## Meeting note

<b>File reference</b>	EN030002 Keuper Gas Storage Project
<b>Status</b>	<b>Final</b>
<b>Author</b>	The Planning Inspectorate
<b>Date</b>	15 July 2015
<b>Meeting with</b>	Keuper Gas Storage Ltd
<b>Venue</b>	Temple Quay House
<b>Attendees</b>	<b>Planning Inspectorate</b> Tom Carpen – Infrastructure Planning Lead Tracey Williams – Case Manager Ewa Sherman – Case Officer Steven Parker – Assistant Case Officer Richard Kent – EIA and Land Rights Advisor <b>Keuper Gas Storage Ltd</b> Paul Zyda - Zyda Law Ian Graves - Zyda Law Richard Stevenson - INOVYN Enterprises Limited Lewis Jones - PPS Group
<b>Meeting objectives</b>	To discuss comments made on the second review of draft documents
<b>Circulation</b>	All Attendees

**HOLFORD BRINEFIELD - KGSP - ABOVE GROUND
WORKS PLAN [REGULATION 5(2)(I)] - SHEET 9 OF 9**

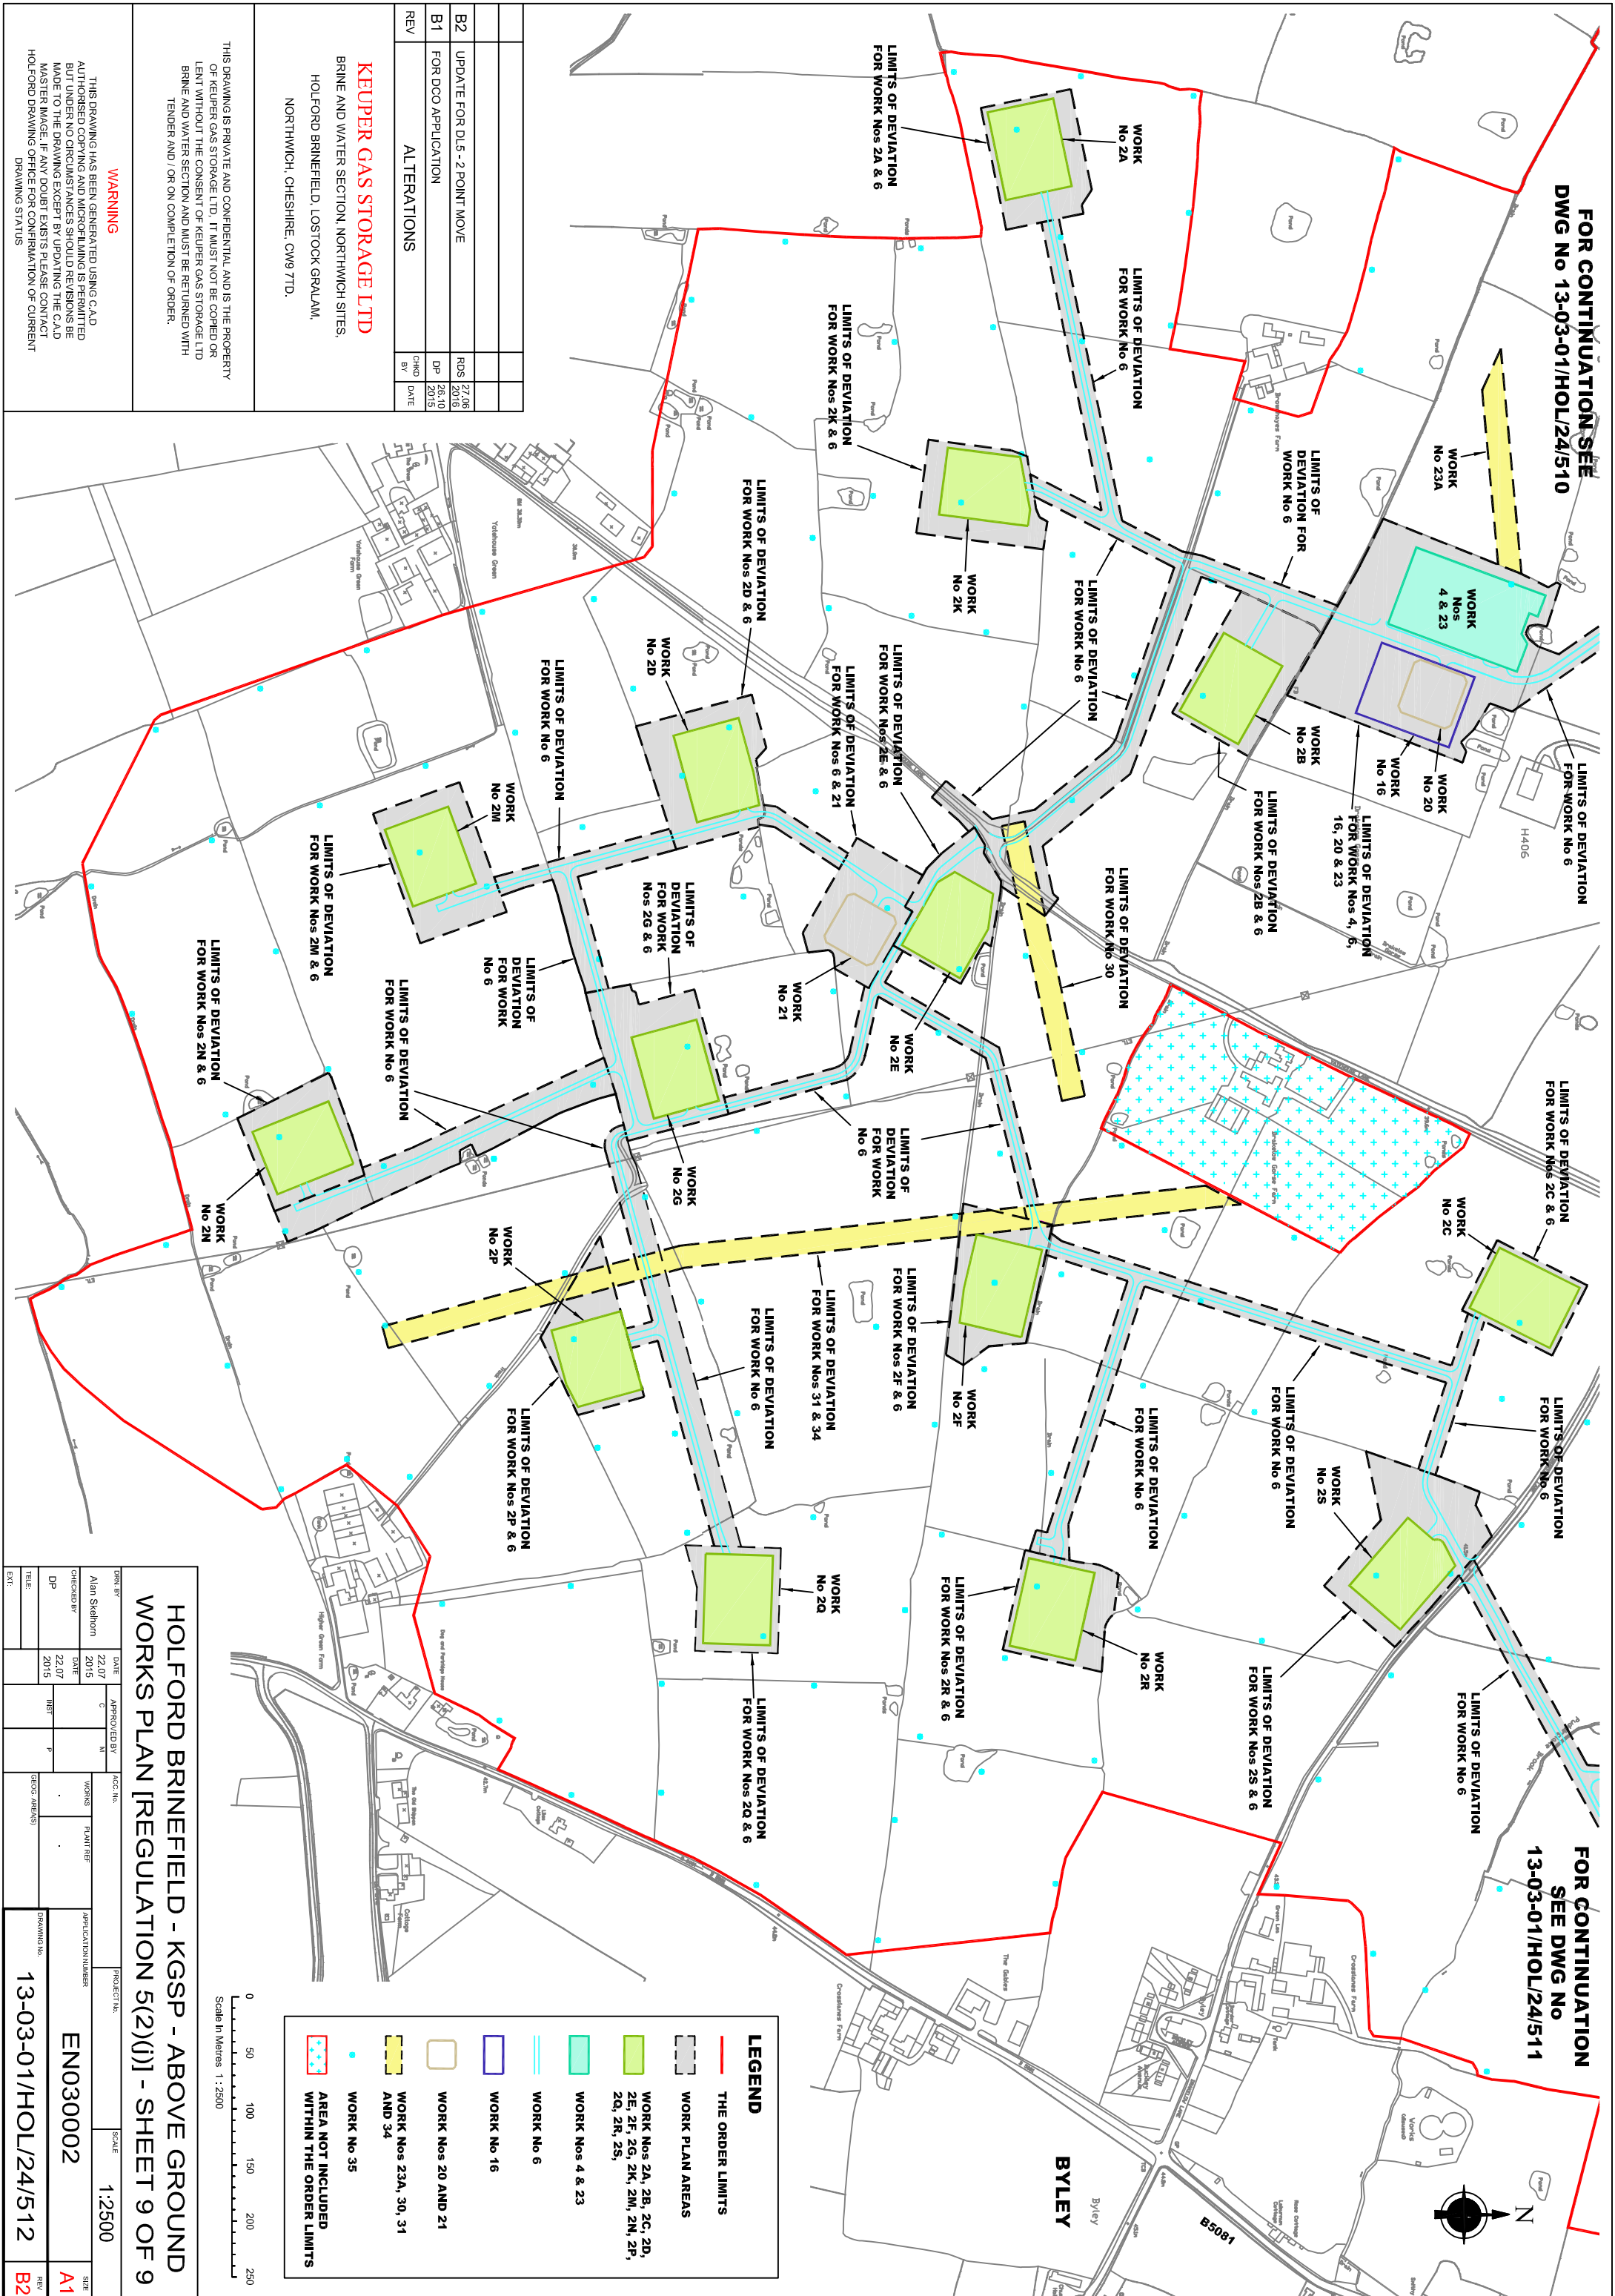
The Inspectorate's comments on the draft documents raised the point that parts of the internal road network (Work No. 6) appears to be on land that would not be acquired by the Applicant.

The Applicant explained their approach to using their designations for wellheads. The Inspectorate understands this approach, but advised that the Work numbers should appear on the plans. Notwithstanding that the Inspectorate agreed to work with the Applicant and so that all plans are legible for all parties.

The Applicant confirmed that the approach used was consistent and that it was their intention that the freehold for the roads would remain with the present owner. Access to use and maintain the roads would be via agreements with the freehold owner.
